Arun District Council
Arun Civic Centre
Maltravers Road
Littlehampton
West Sussex BN17 5LF
Planning & Building Control General Enquiries
Tel: (01903) 737756 Fax: (01903) 730442
Dx: 57406 Littlehampton
Minicom: 01903 732765
e-mail: planning@arun.gov.uk
website: www.arun.gov.uk/planning

Application No: WA/93/20/PL
Site Address: Land East of Tye Lane Walberton BN18 0LU
Description of works: Alternative vehicular access off Tye Lane & emergency access off Avisford Park Road, along with minor highway works following WA/95/18/RES. This site is in CIL Zone 2 (Zero Rated) as other development.

Thank you for your internet representation made on 10th May 2021 which has been recorded as an objection with the comments as follows:

Emergency access off Avisford Park Road:

AVISFORD PARK ROAD

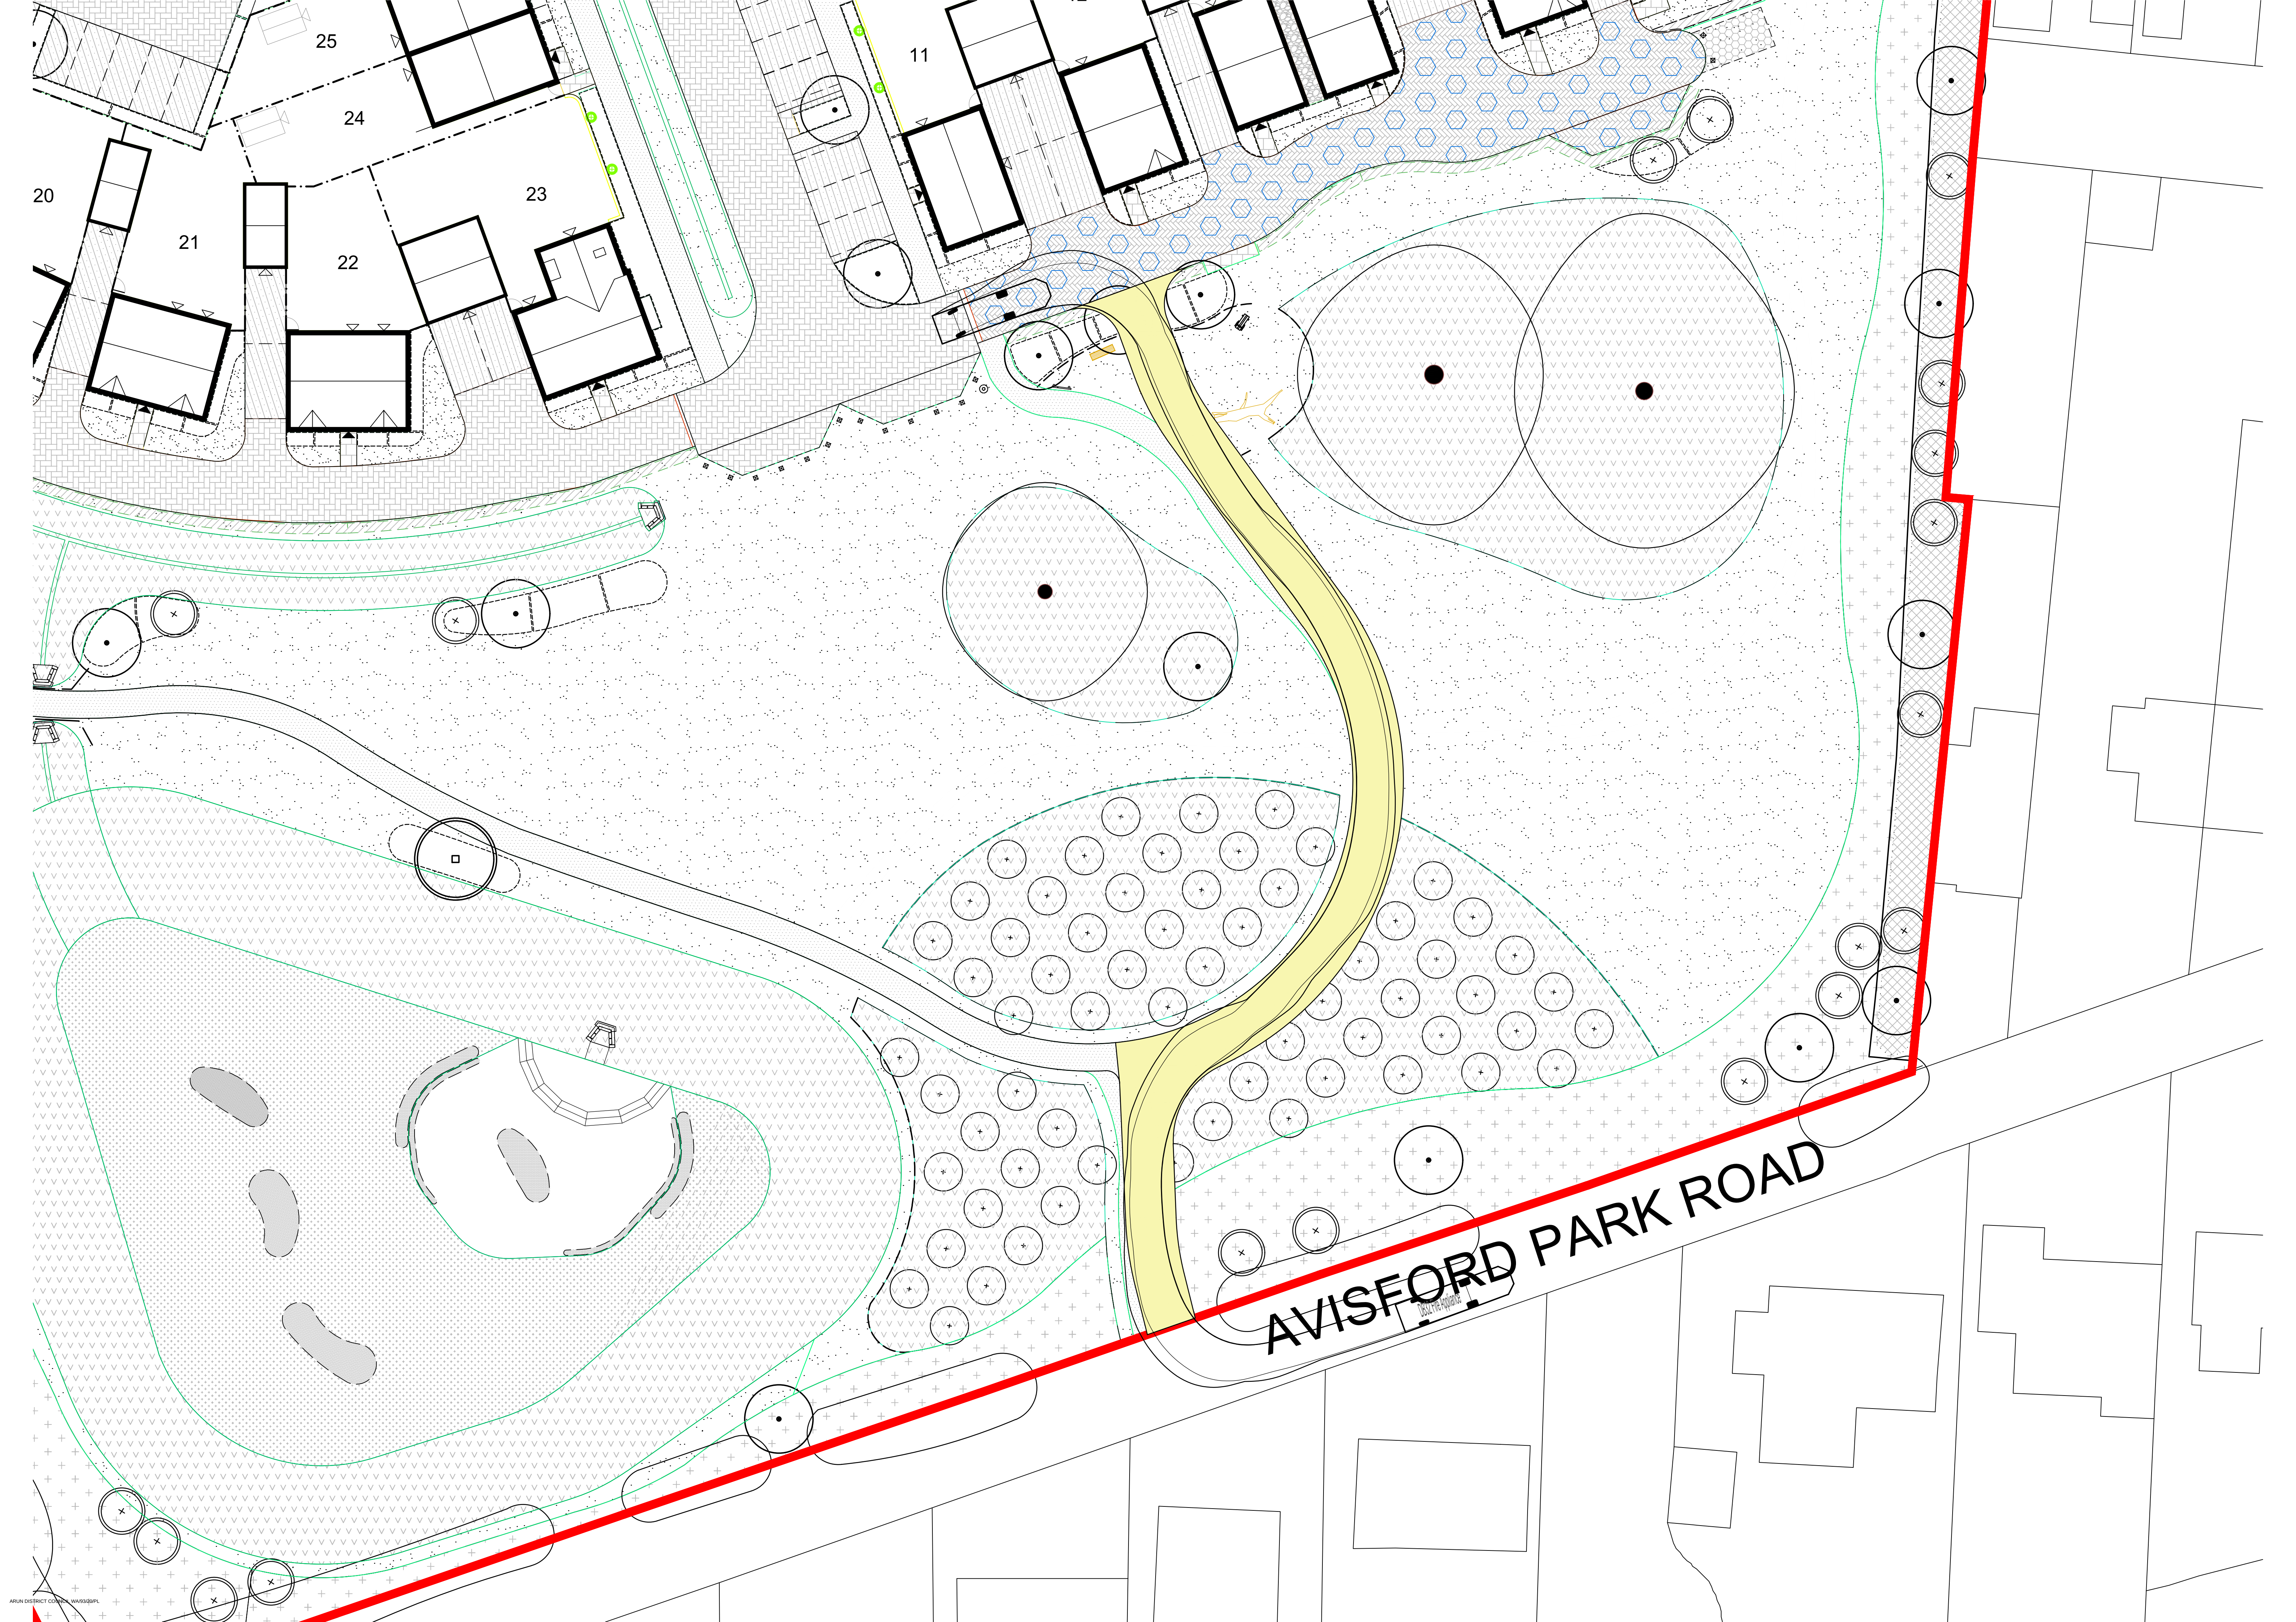
1. The single bollard at each end of the proposed emergency access is insufficient to prevent its use by vehicles such as motor cycles or quad bikes, putting the safety of pedestrians using the public footpath on Avisford Park Road at very high risk, particularly where the proposed emergency access meets the existing public footpath. With a proposed access width of 3.5 metres, it is possible that cars may also attempt unauthorised use as a short cut to and from the Avisford Grange development. An L-chicane should be installed at each end to ensure the safety of all users: this, of course, is incompatible with its use by emergency vehicles.

2. Any widening of the already approved path in order to facilitate use by emergency vehicles is likely to impinge on the (already agreed and approved) public open space and may impact the roots of the three protected trees. Both factors should render the proposal unacceptable.

3. Any additional lighting at the junction of the proposed emergency access with Avisford Park Road should be in accordance with Walberton Neighbourhood Plan Policy VE 8 'Unlit village' status.

4. Removal of established and existing hedgerow to accommodate access from Avisford Park Road would destroy wildlife habitat and nesting sites for birds as well as natural screening of the new development from Avisford Park Road. This is a material change from the approved application, with the existing estate fencing to be replaced with 'like for like'.
